A1 in Northumberland: Morpeth to Ellingham

Scheme Number: TR010059

7.25 Applicant's Comments on Responses to Further Written Questions

**Applicant's Comments on Responses to Further
Written Questions**

© WSP UK Ltd

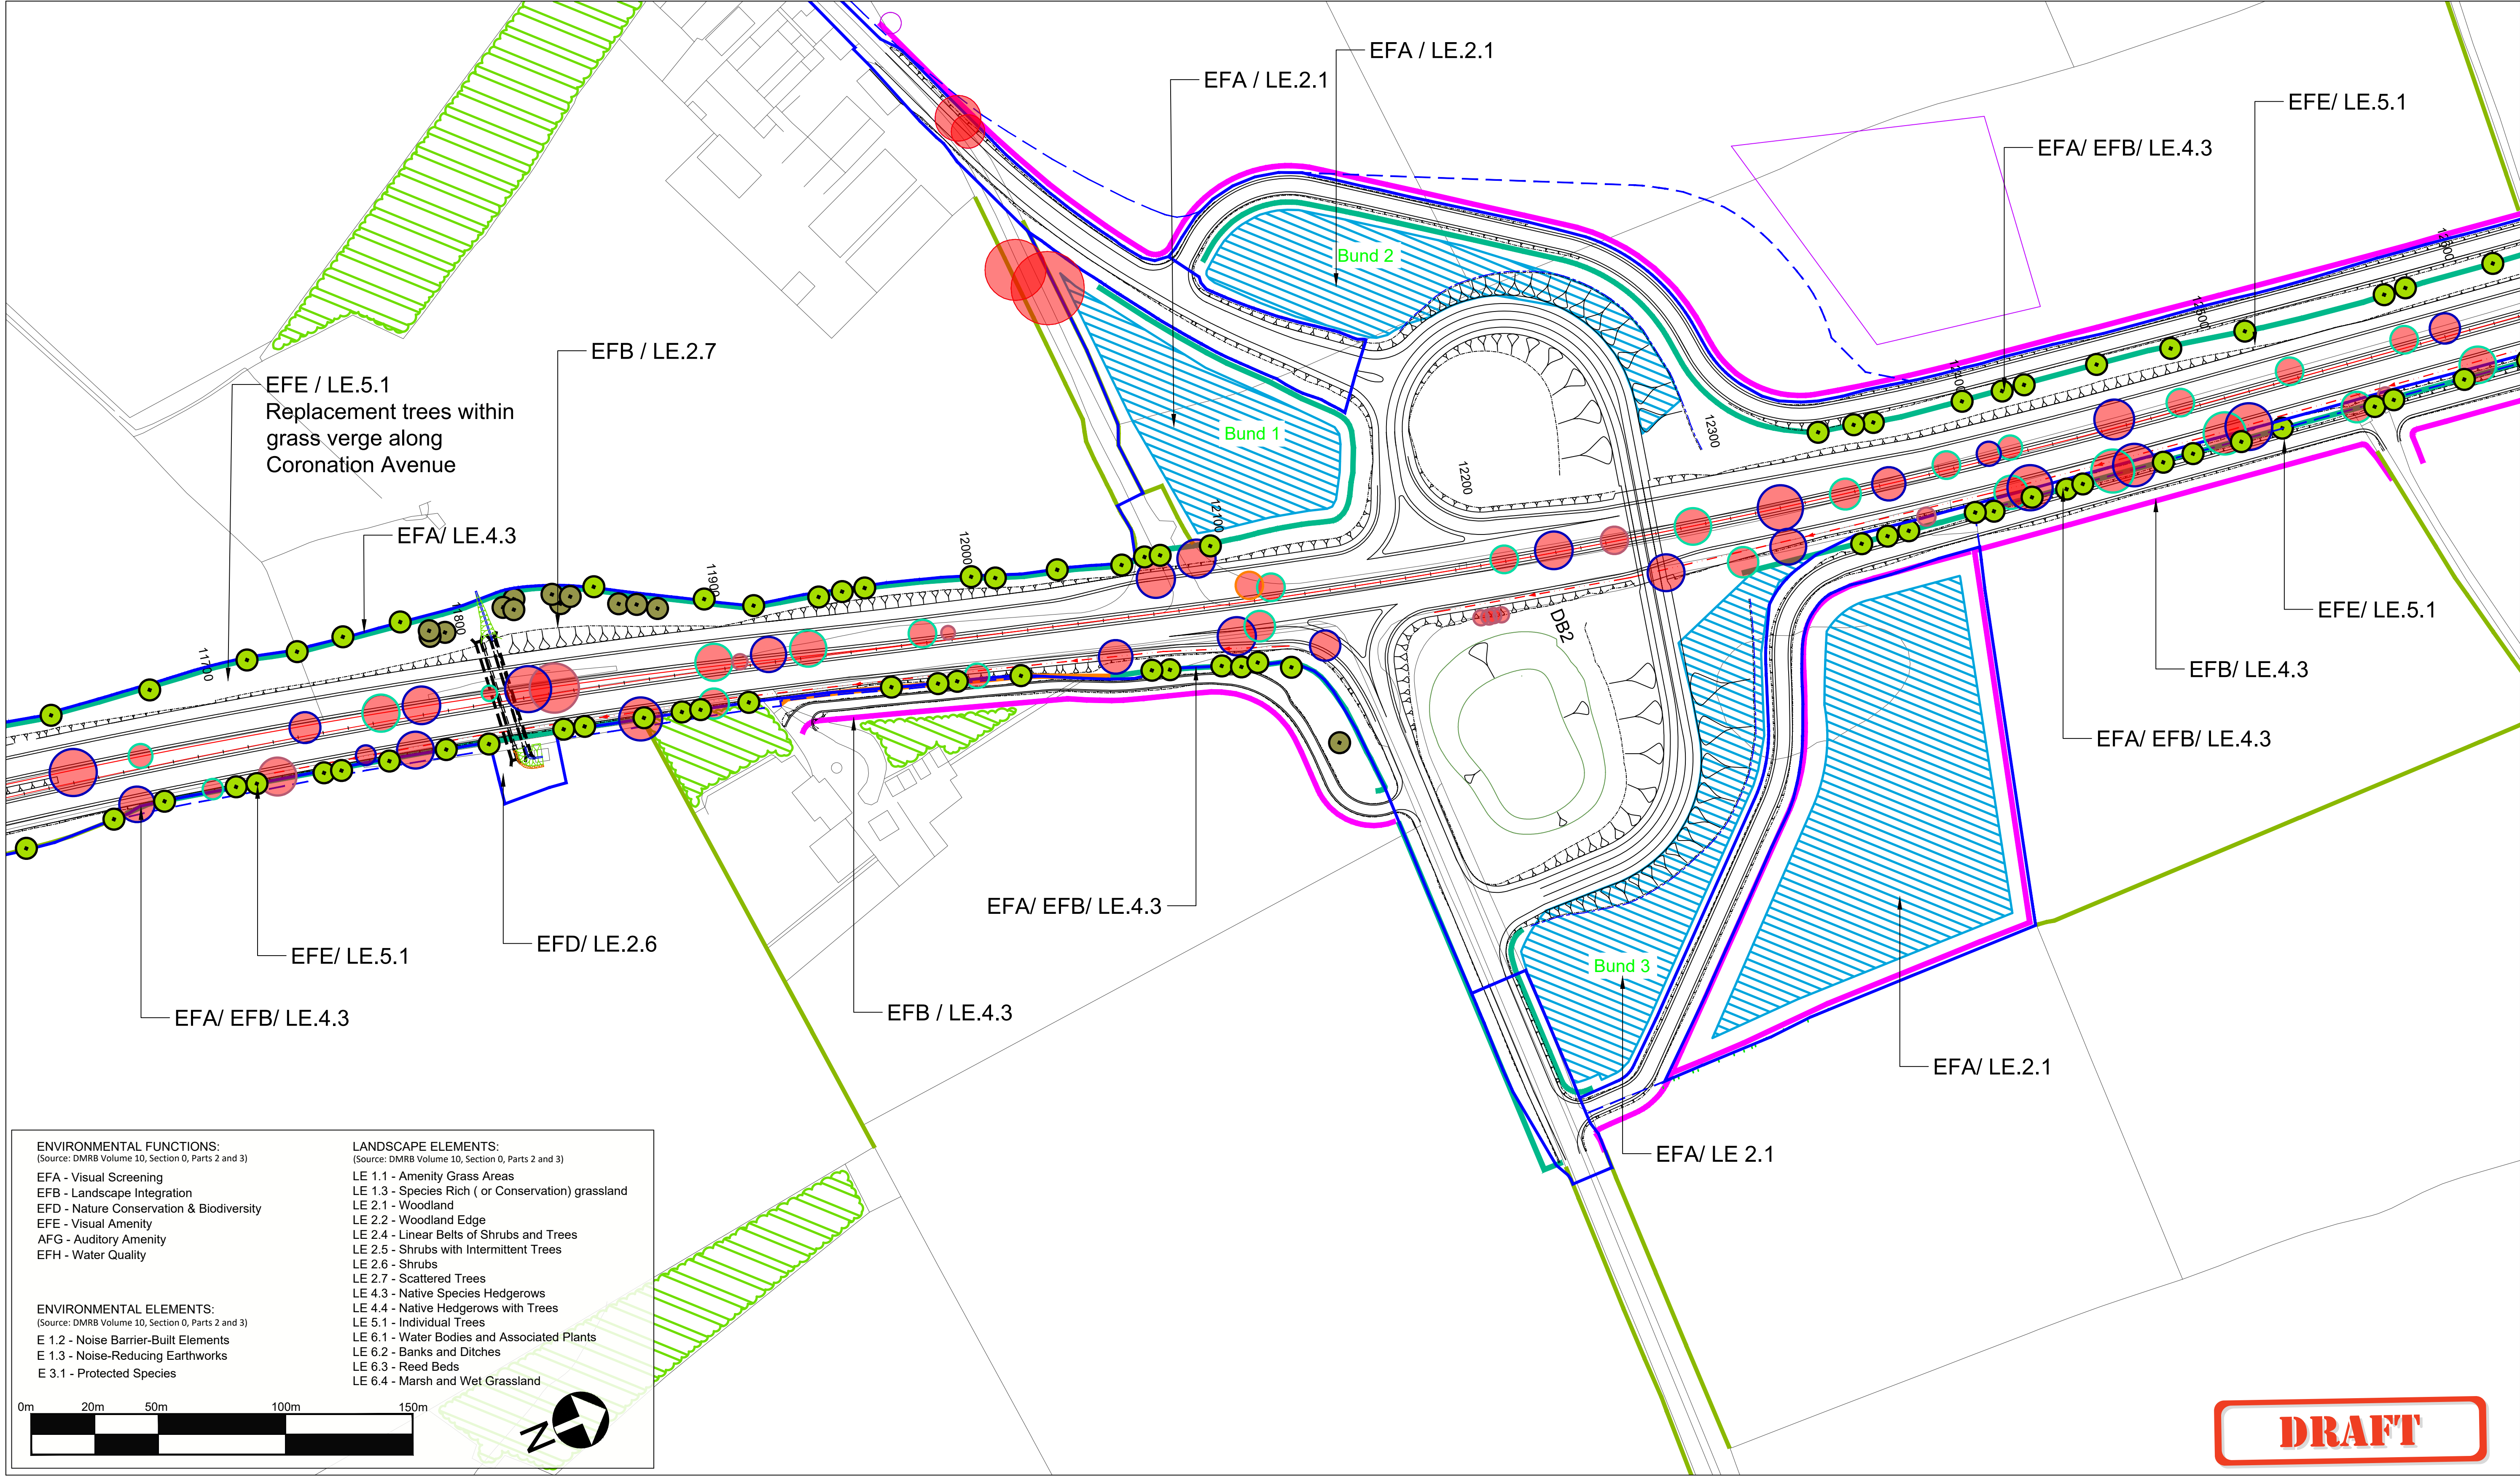
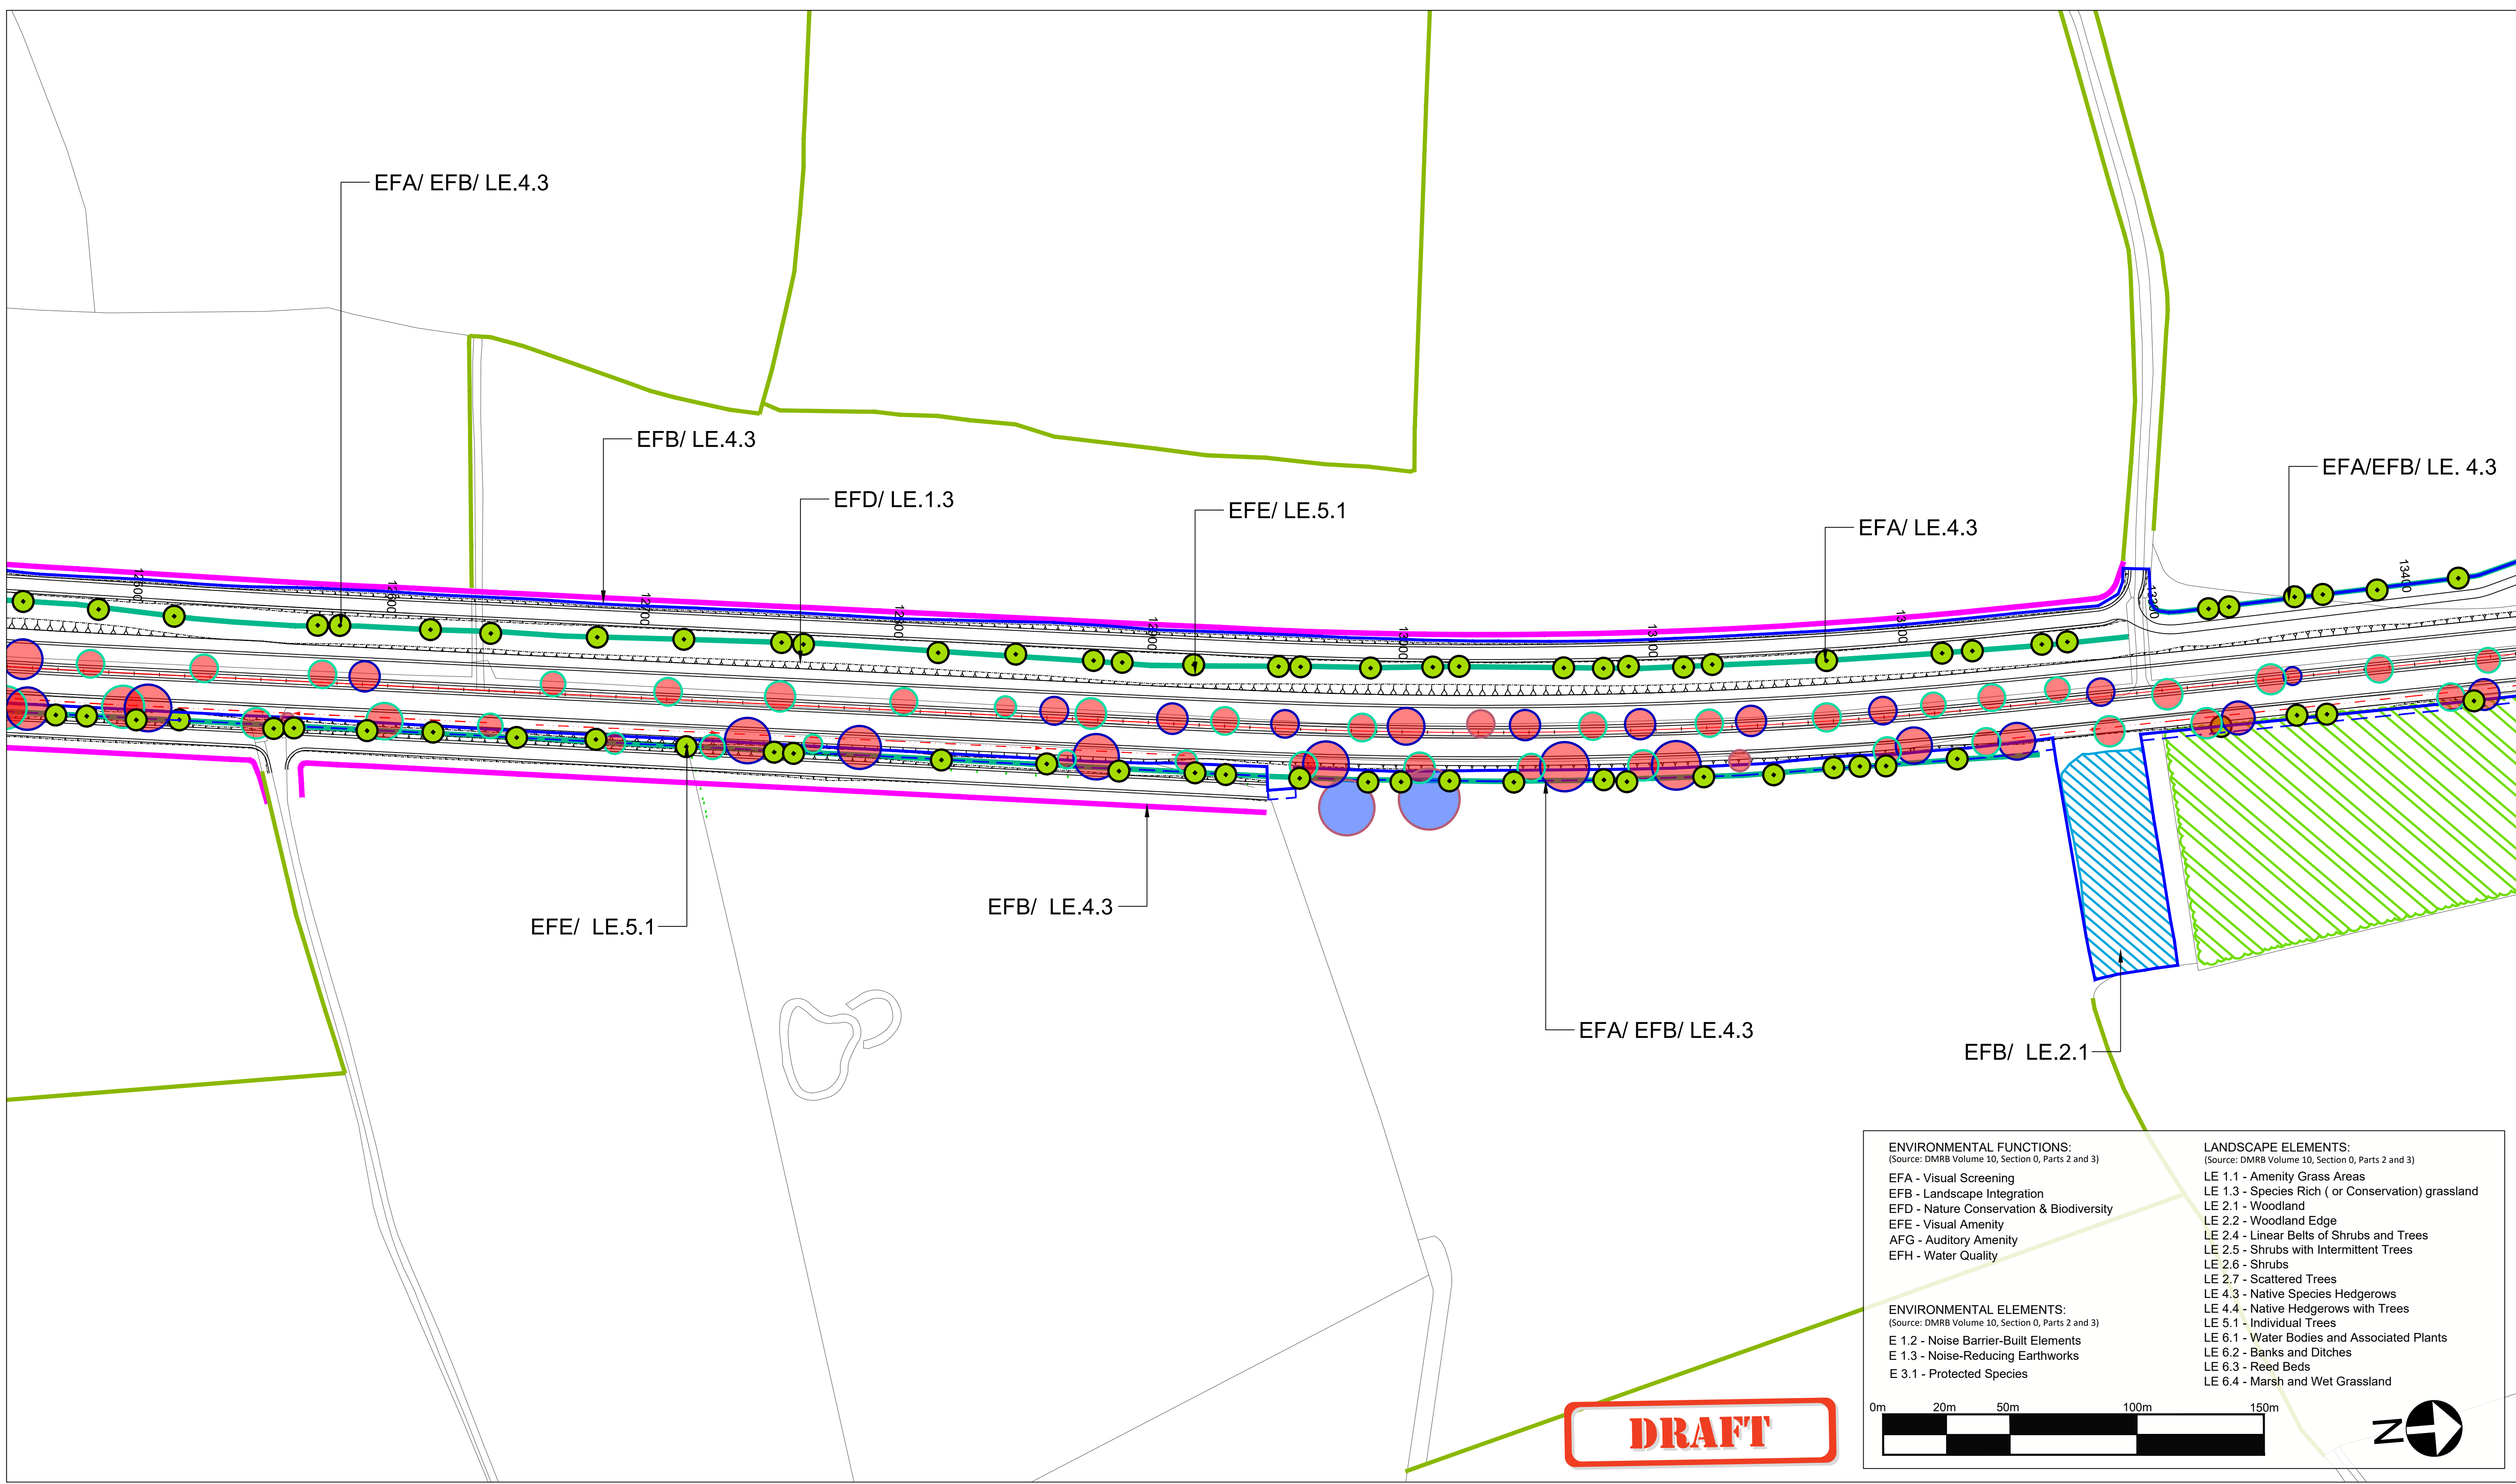
Ref. No.	Question to	Question	Interested Party's Response	Applicant's Response
LV.2.2 1.	Applicant IPs	The plans which form Appendix LV.2 Trees to be Removed and Replaced at Coronation Avenue WQ LV.1.8 [REP1-044] are annotated 'Draft'. The Applicant is asked to explain how this relates to the requirement in R5(3) of the dDCO for the landscaping scheme to include a strategy for the replacement of trees which are to be removed at Coronation Avenue? IPs are asked to comment on the proposals for Coronation Avenue.	In reviewing this documentation again, I remain disappointed by the scale of tree loss inflicted by the scheme. Undoubtedly the biggest impact is on the distinguished Coronation Avenue of trees which line both sides of the single carriageway. I am not aware of any other A classed road in the country which can boast such an extensive configuration of mature trees, which are now approaching 70 years age. The main source of frustration stems from an underlying belief that more could have been done to protect the trees and improve the levels of mitigation. For example, most of the work carried out on the existing road is asymmetric which means that the	<p>1. The removal of the trees at Coronation Avenue is necessary in order to construct the Scheme, either through direct loss of the trees or impacts on their roots that in the long term would reduce their viability. The removal of vegetation would be avoided where possible to safeguard any remaining trees, including those that make up the Coronation Avenue. This is secured through item SL-2 of Table 3-1 - Register of Environmental Actions and Commitments: The Scheme in Outline CEMP [REP5-012 and 013] (and as updated at Deadline 6).</p>

2.			<p>In total it appears that circa 200 coronation trees are to be felled and replaced with young trees which I understand will take a minimum of 15 years to mature. Even then the visual impact and environmental contribution will remain well short of what we enjoy today.</p>	<ol style="list-style-type: none"> 1. The Scheme would require the removal of existing roadside hedgerows and removal of 187no. existing trees that form the Coronation Avenue of trees. 2. The replacement of trees would be undertaken using advanced nursery stock, and this is secured through item SL-4 of Table 3-1 - Register of Environmental Actions and Commitments: The Scheme in Outline CEMP [REP5-012 and 013] (and as updated at Deadline 6). What this means in practice is that the trees would be of larger size when planted, being a minimum of 3m in height. The final height of the tree will depend upon the species selected. 3. It should be noted that trees will establish and grow continually until they reach maturity. The reference to 15 years is taken from the guidance for landscape and visual assessment, DMRB 135/10, a link to which is provided within Applicant's Responses to the ExA's Further Written Questions - Appendix C - Former and Updated DMRB Guidance [REP5-026]. This requires the assessor to consider the impact of the Scheme in the summer of year 15, when it is assumed that for the most part the planting will have sufficiently established in order to fulfil its function as mitigation. Trees, including those planted to replace the Coronation Avenue will continue to mature up to and beyond year 15. However, in the meantime

3.			<p>In looking at the plans for the new arrangement of replacement trees the Avenue effect would appear to have been lost. The configuration of the trees is no longer linear and there are too many gaps in the flow to emulate the Avenue effect. Furthermore, the distances between the trees flanking each side of the road are over 50 metres in some cases.</p>	<p>1. The strategy for the replacement of the Coronation Avenue, as agreed with NCC, is shown on Landscape Mitigation Masterplan Part A for Change Request Rev 3 [REP4-060], and secured through item S-L2 (c) of Table 3.1 – Register of Environmental Actions and Commitments: The Scheme in the Outline CEMP [REP5-012 and 013] (and as updated at Deadline 6). The strategy for the replacement of the trees that contribute to the Coronation Avenue would be on a like for like basis in terms of numbers and would replace the important landscape feature that would be impacted by Part A with an informal avenue effect, rather than 'pairs' of opposing trees, and which would be similar to what is currently experienced. This is identified in paragraph 7.9.14 (a) of Chapter 7: Landscape and Visual Part A [APP-044]. The replacement trees would also comprise more advanced nursery stock (and would therefore be larger and more discernible than transplants, which would make up the bulk of the mass planting of woodland and scattered trees), this is identified in paragraph 7.9.14 (h) of Chapter 7: Landscape and Visual Part A [APP-044].</p> <p>2. The replacement planting along the wider corridor would increase the width between the lines of trees either side of the Scheme. However, the replacement strategy is such that, over time, the tree lined nature</p>

Ref. No.	Question to	Question	Interested Party's Response	Applicant's Response
				<p>of the corridor would be substantially restored to form an informal avenue that would be a key feature of the view travelling along the A1, similar to what is experienced currently. The replacement strategy is identified on Landscape Mitigation Masterplan Part A for Change Request Rev 3 [REP4-060] submitted at Deadline 4, and secured through item S-L2 (c) of Table 3.1 – Register of Environmental Actions and Commitments: The Scheme in the Outline CEMP [REP5-012 and 013] (and as updated at Deadline 6). As such, the informal avenue effect would over time be restored.</p>
LV.2.6 1.		Appendix LV3 Response to LV.1.13 [REP1-051] considers potential additional mitigation measures, their suitability and the prospect of potentially reducing significant effects to non-significant. What are the views of IPs in respect of these further potential mitigation measures?	Although the opening paragraph does make the claim that additional mitigation may reduce significant effects to non-significant, I could not find any example in the rest of the document which suggested that this had been achieved.	<ol style="list-style-type: none"> 1. Within Appendix LV3 Response to LV.1.13 [REP1-051] consideration was given as to whether additional mitigation might reduce significant effects to non-significant. The Applicant reviewed the mitigation strategy for those receptors where a significant effect was anticipated to remain following construction of the Scheme and considered whether the effect could be reduced should further measures be identified. The conclusion of that review for all locations assessed was that further screening, in the form of planting or fences, would not provide sufficient mitigation or might in themselves result in impacts on views and/or changes to landscape character. As such, further screening is not proposed as part of the Scheme.
